From: Amber Willard
Sent: 15 April 2019 10:48
To: Planning.Responses
Subject: FW: FP/46/19/PL
Attachments: APL 05.3 plans.pdf; APL 06.3 roof plan and sections.pdf

From: Amber Willard [REDACTED]
Sent: 12 April 2019 16:28
To: Ray Bell [REDACTED]
Subject: FP/46/19/PL

I am the case officer on your application FP/46/19/PL at 28 Sea Drive.

B Proposed amendment to existing consent FP/205/18/HH

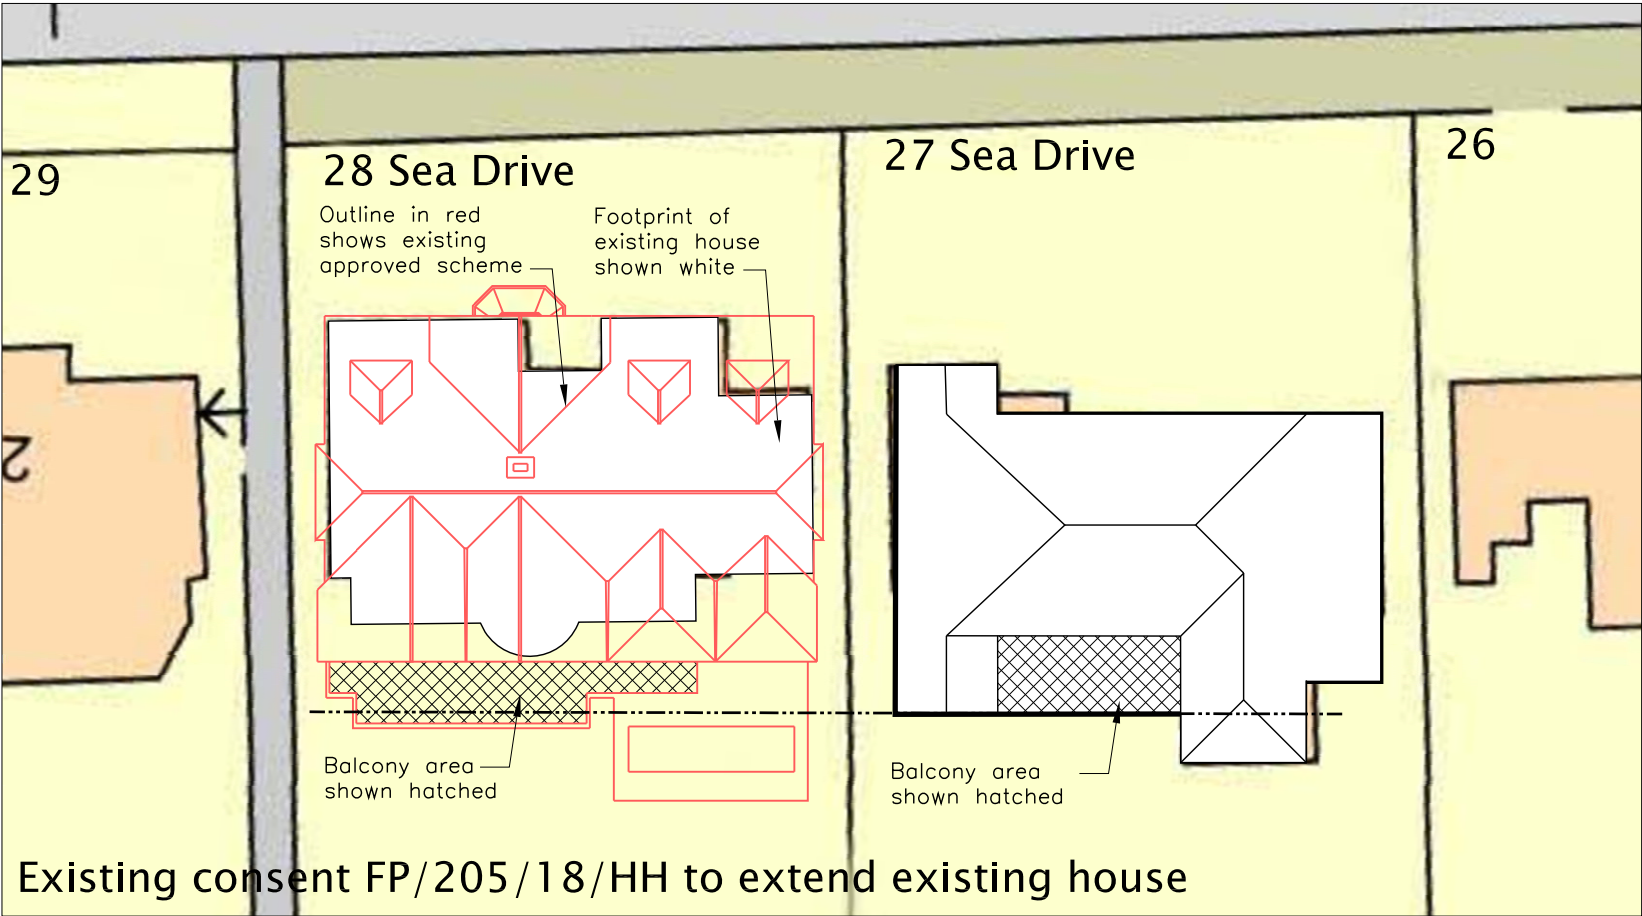
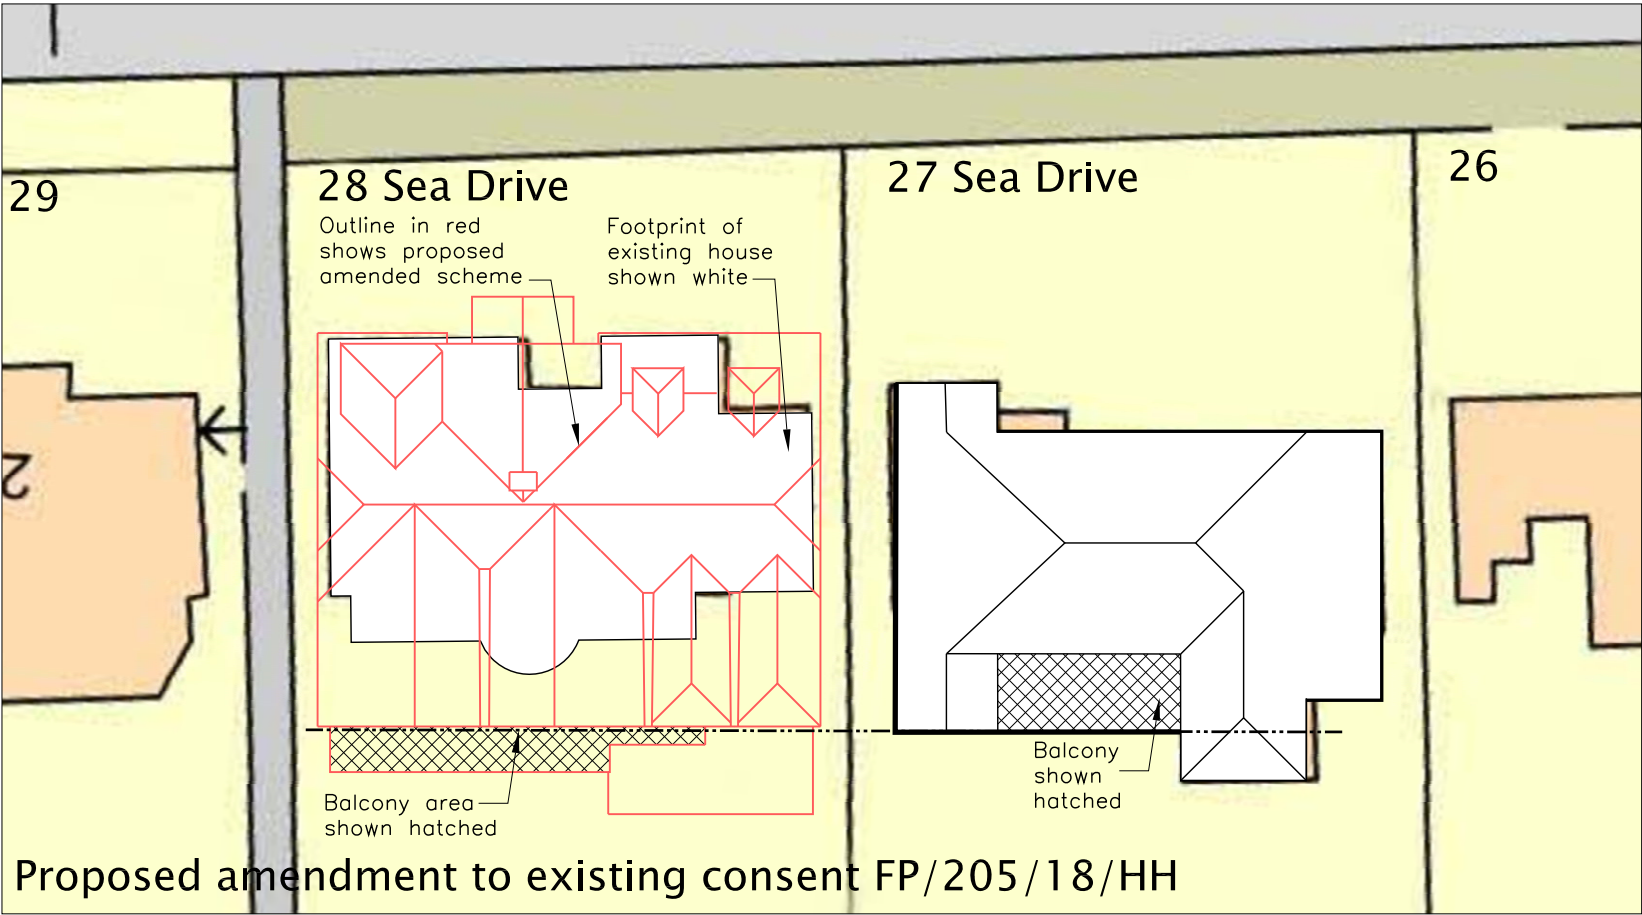
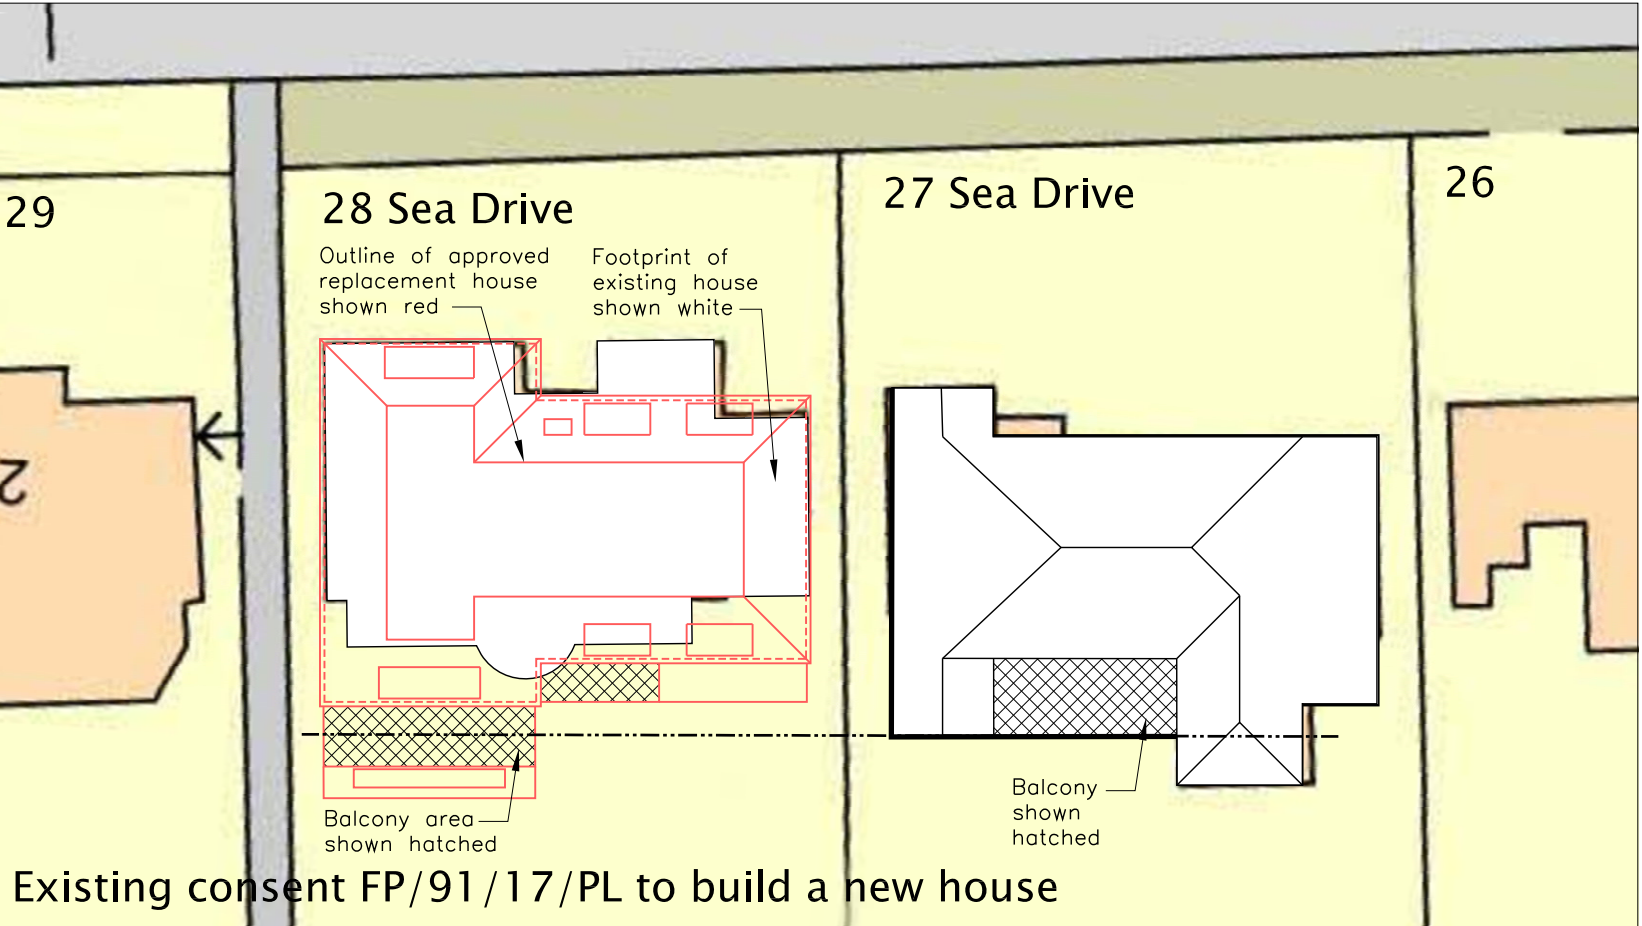
On the existing and proposed block plan B (proposed amendment to FP/205/18/HH) the plan shows the balcony retaining around 3.5m to the eastern elevation.

Block plan B is correct - the intended balcony stops short and the eastern-most windows at first floor have a Juliette balcony.

Dwg Reference:
Ground & first floor level plans
as proposed

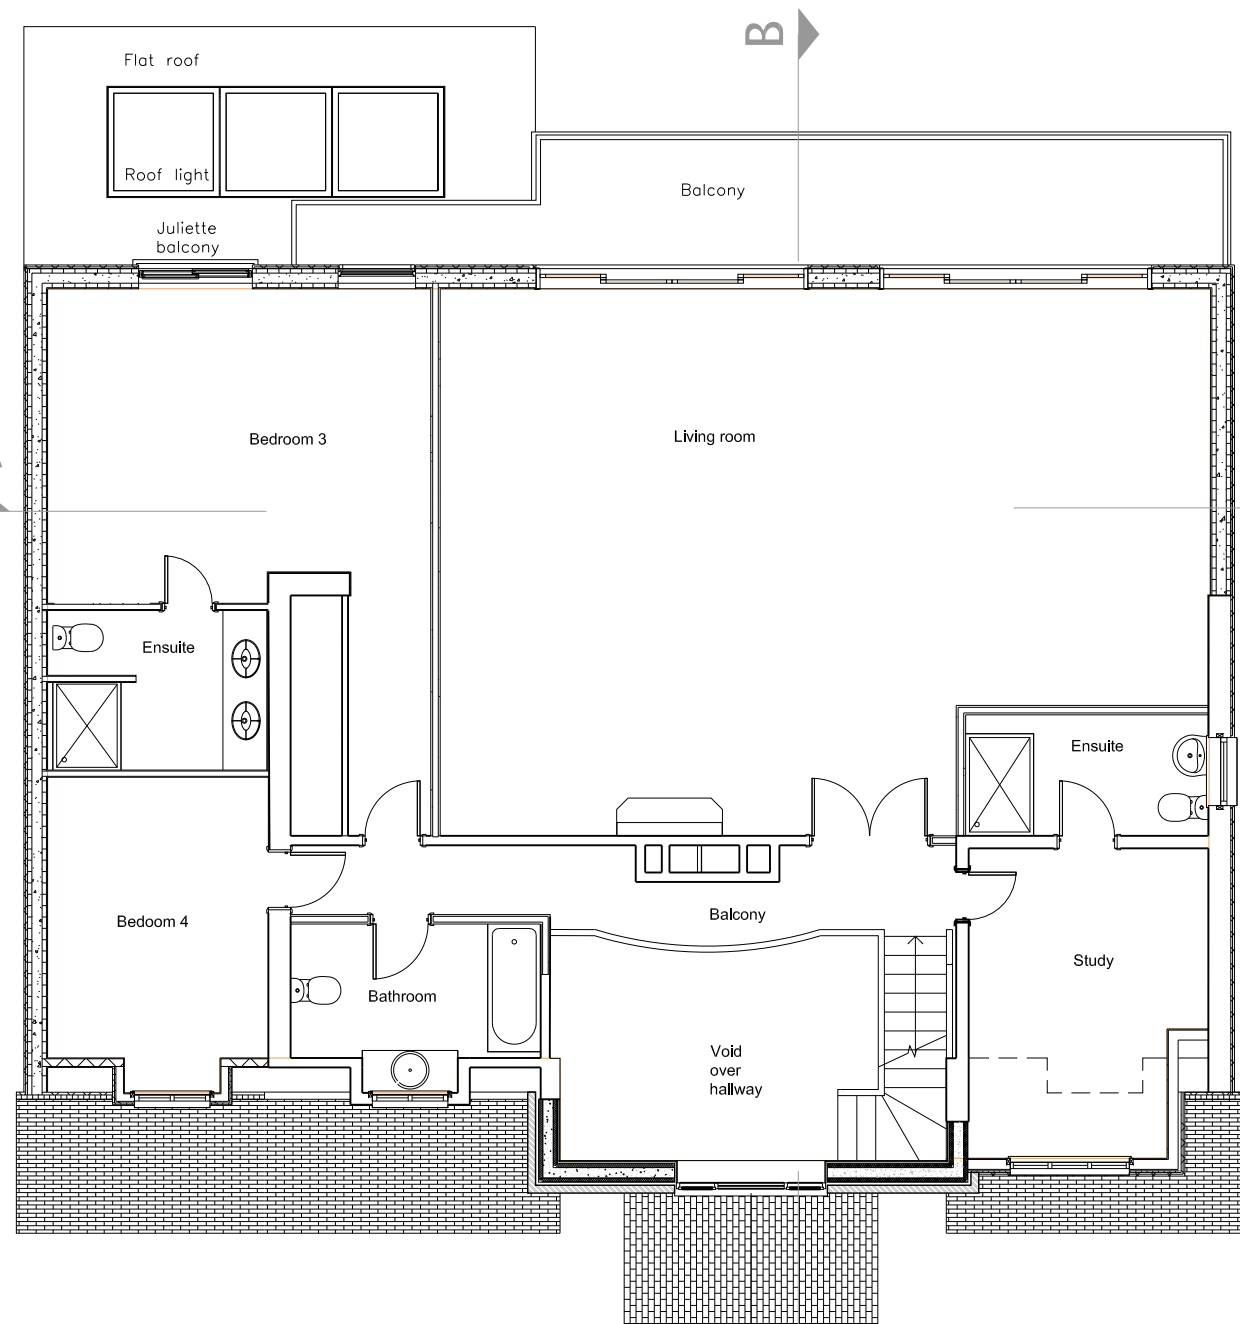
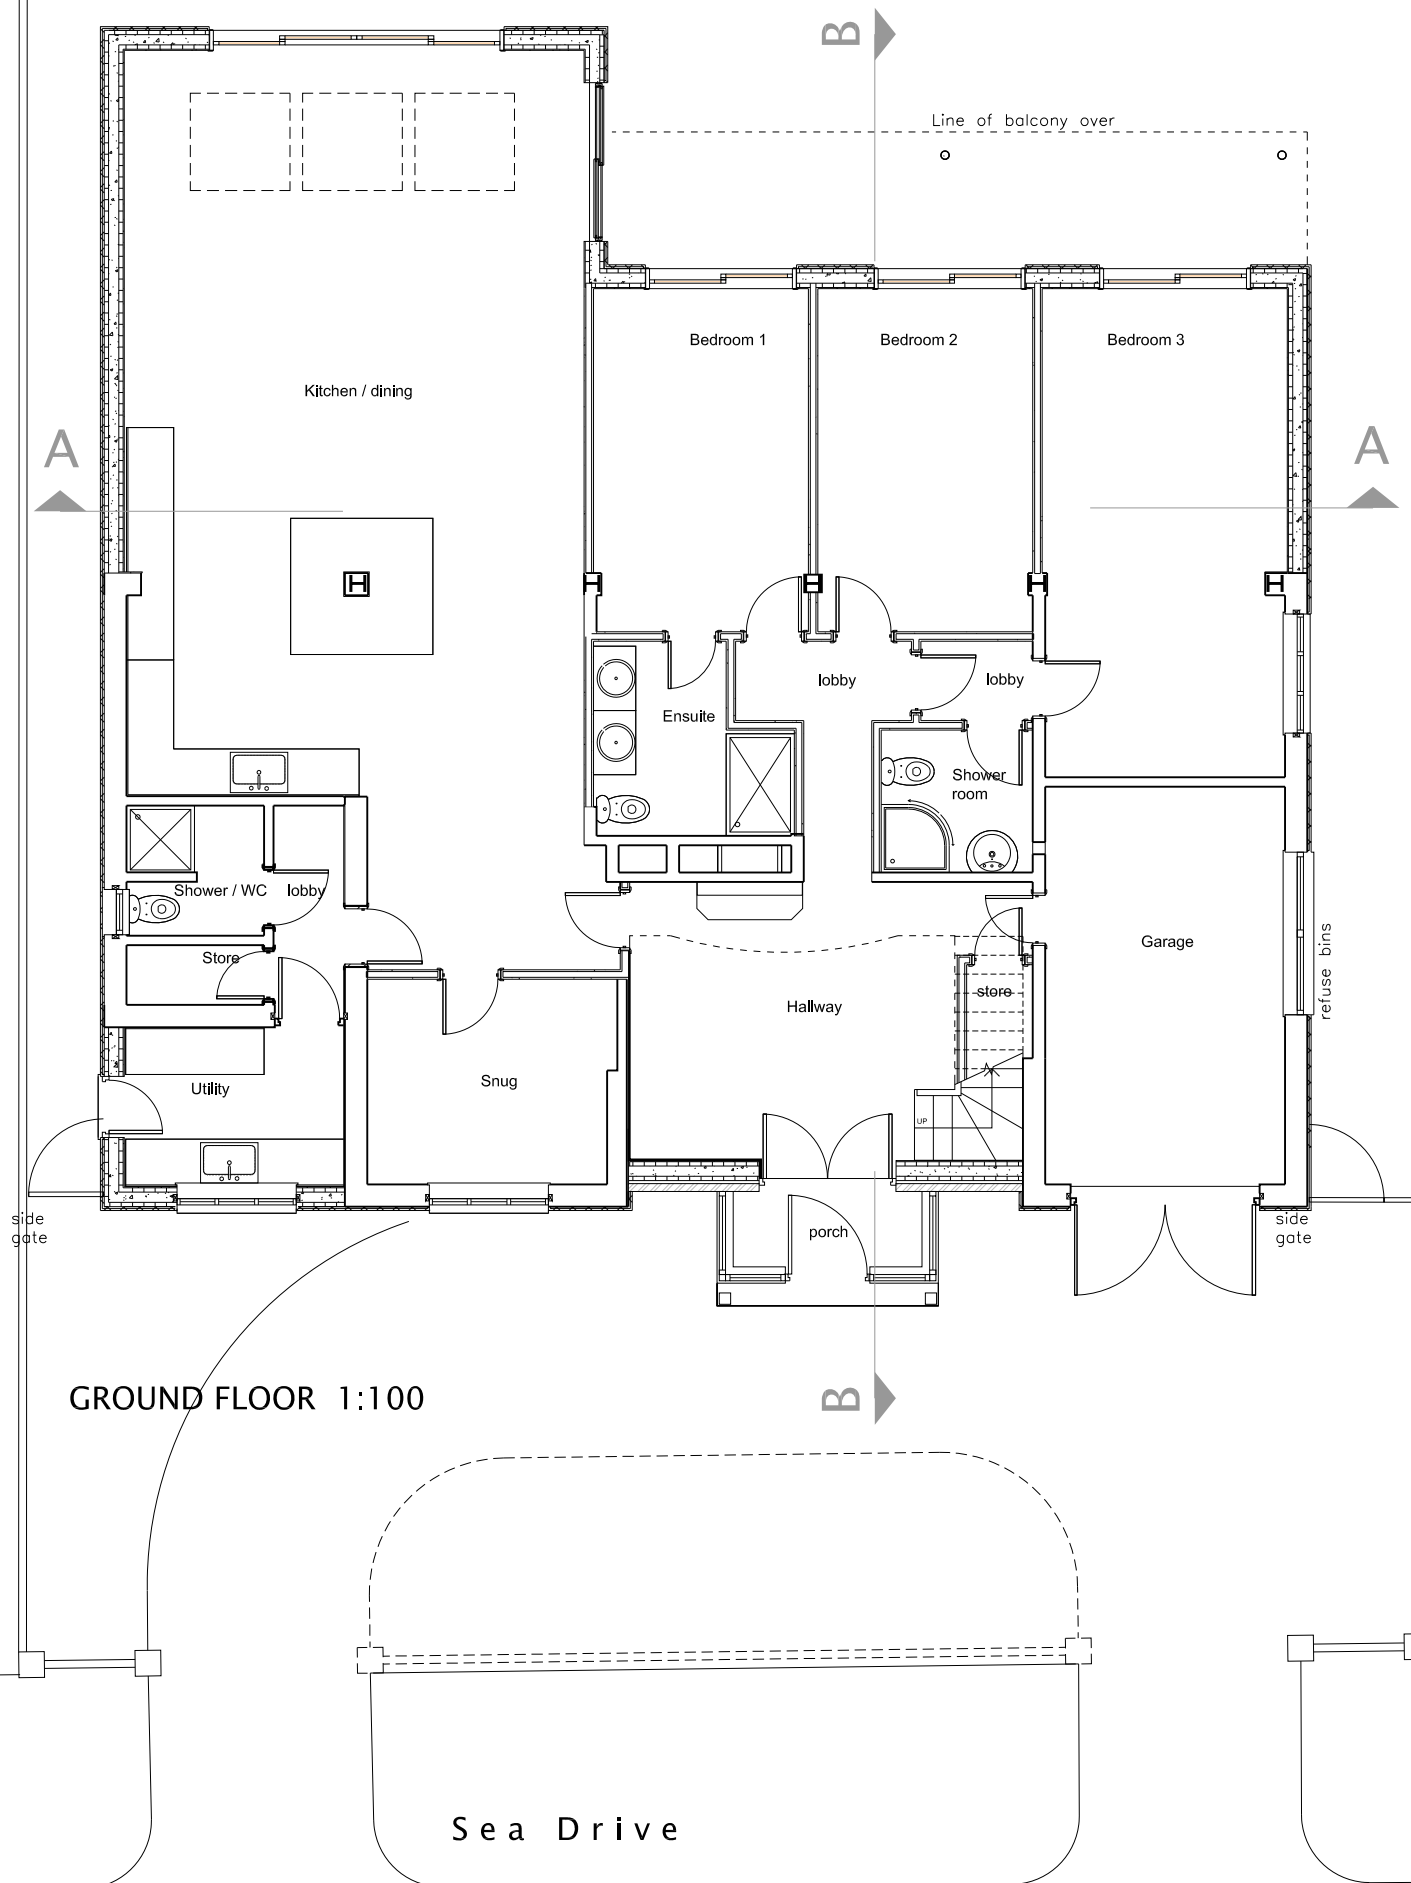
However on the proposed elevations ,roof and floor plan the balcony appears to have been extended towards the east and only retains around 1.3m

My apologies, I inadvertently sent out-of-date plans. The attached drawings APL 05.3 and APL 06.3 show the correct layout.
